Recommendation Report for Planning Permission for Works or Extension to a Dwelling

REF NO: AL/93/21/HH

LOCATION: 23 Olivers Meadow
Westergate
PO20 3YA

PROPOSAL: 2 storey side extension

Drawing: PROPOSED

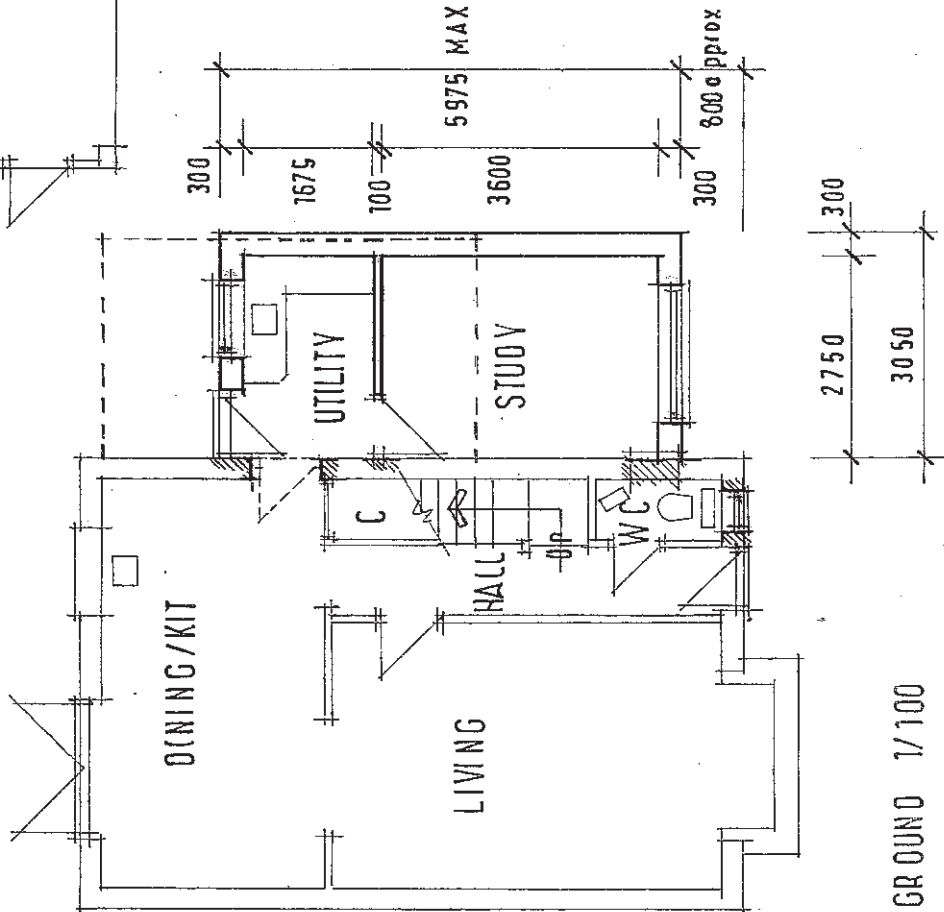
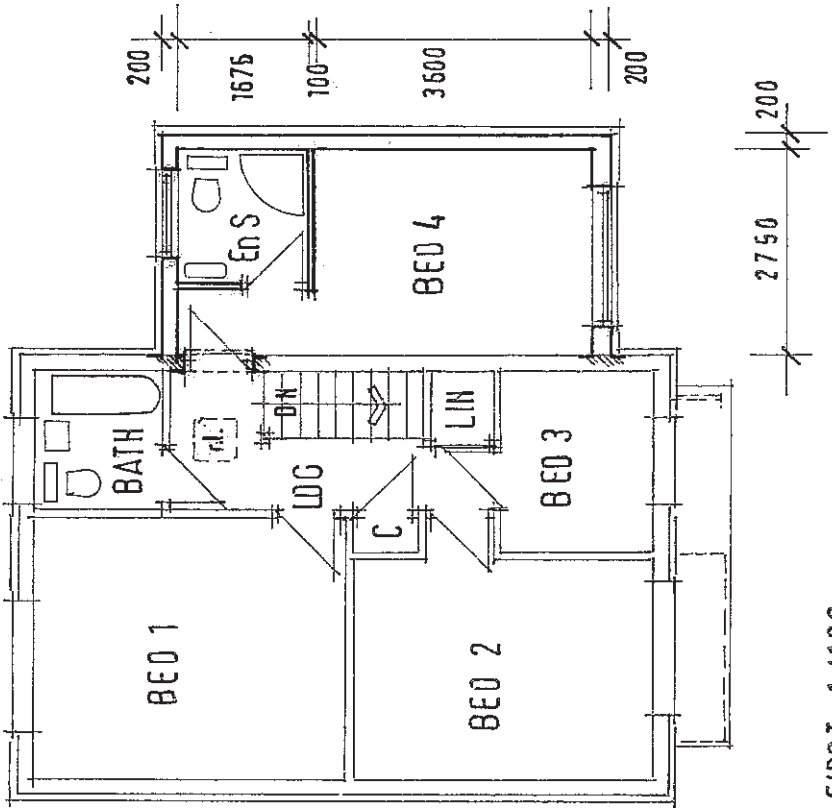
The proposal appears well integrated with the host dwelling and is modest in size situated slightly behind the principal elevation by around 0.75m. The roof will be pitched, set slightly below the ridge height. Approximately 4.5m will be retained to the front boundary and 7.25m to the side boundary. The extension therefore retains separation and does not appear unduly dominant in appearance.

The proposal will run along the eastern side of the property. It retains 1.5m to the rear elevation and due to the siting of the extension, with the road alongside, it will not result in adverse overbearing or overshadowing. The width is modest at 3m, matching that of the conservatory which will be removed.

There will be an additional first floor window which looks north, although due to the siting of the neighbouring properties, views will be of the front garden of the rear dwelling. The window will however serve a bathroom and it will be conditioned to remain obscured glazed to ensure no adverse views are available.

An additional window and door to the ground floor will have views of the garden of the host dwelling and are not considered additional to that which is already achievable. 2 additional windows to the front will look over the street scene.

Reason: In the interests of amenity in accordance with policies D DM1 of the Arun Local Plan.
- 4 The first floor window on the northern elevation of the building shall at all times be glazed with obscured glass and only openable at a high level, at least 1.7m above finished floor level.
